Case Officer: Emma Whitley

Proposal: Two storey front and rear extensions, with new pitched roofs replacing flat roof area to side of the property. Enlargement of vehicle access width in stone boundary wall (resubmission of 20/02280/F)

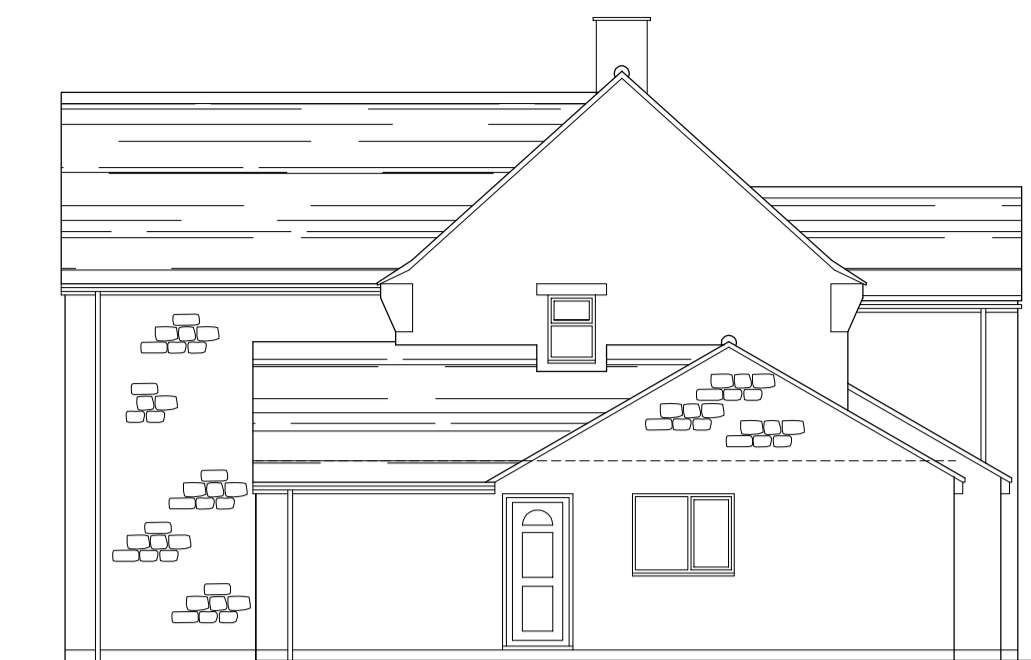
The proposals have been amended following the previously proposal, so that the front gable extension would demonstrate subservience to the main dwelling and would present a feature to break up the linear form of the existing dwelling. The

proposed front double height extension is not ideal particularly given the 2007 Design Guide and the situation of the application site being within the setting of the Bodicote Conservation Area. However, there are a number of examples of front extensions of a similar height and scale within the setting of the Bodicote Conservation Area, the proposals have been reduced in scale and height, and the proposed materials would be in-keeping with the main dwelling. On balance, I consider the front extension element not to result in demonstrable harm to the designated heritage asset and is therefore considered acceptable.

Following feedback provided in the 2020 refused application, the side extension has been amended to be single storey in scale. It is unfortunate that the side extension element extends beyond the principal elevation, however this is following the existing footprint of the main dwelling. The side extension element is still considered to alter the simple form of the existing dwelling; however, the proposals have been amended in order to take into account the amenities of the adjacent neighbour.

The roof ridge height of the single storey side extension would measure approximately 4.3 metres and would have an eaves height of 2.3 metres, which is considered to still be of a considerable height given its single storey scale. The proposals have not been reduced compared with the plans submitted at pre-application stage, however I do not consider that this element would result in demonstrable harm with regards to the Old Thatch and are therefore not so harmful so as to warrant refusal.

The rear extensions would cause minimal impact to the amenities of the residents of the Old Thatch as it would be stepped back approximately 4 metres and would have no windows facing them. The two-storey extensions would be approximately 7 metres from the residents at Spring Cottage. However, given the relationship and orientation of the two buildings, on balance, I am satisfied that any harm would be limited and would not warrant a refusal.
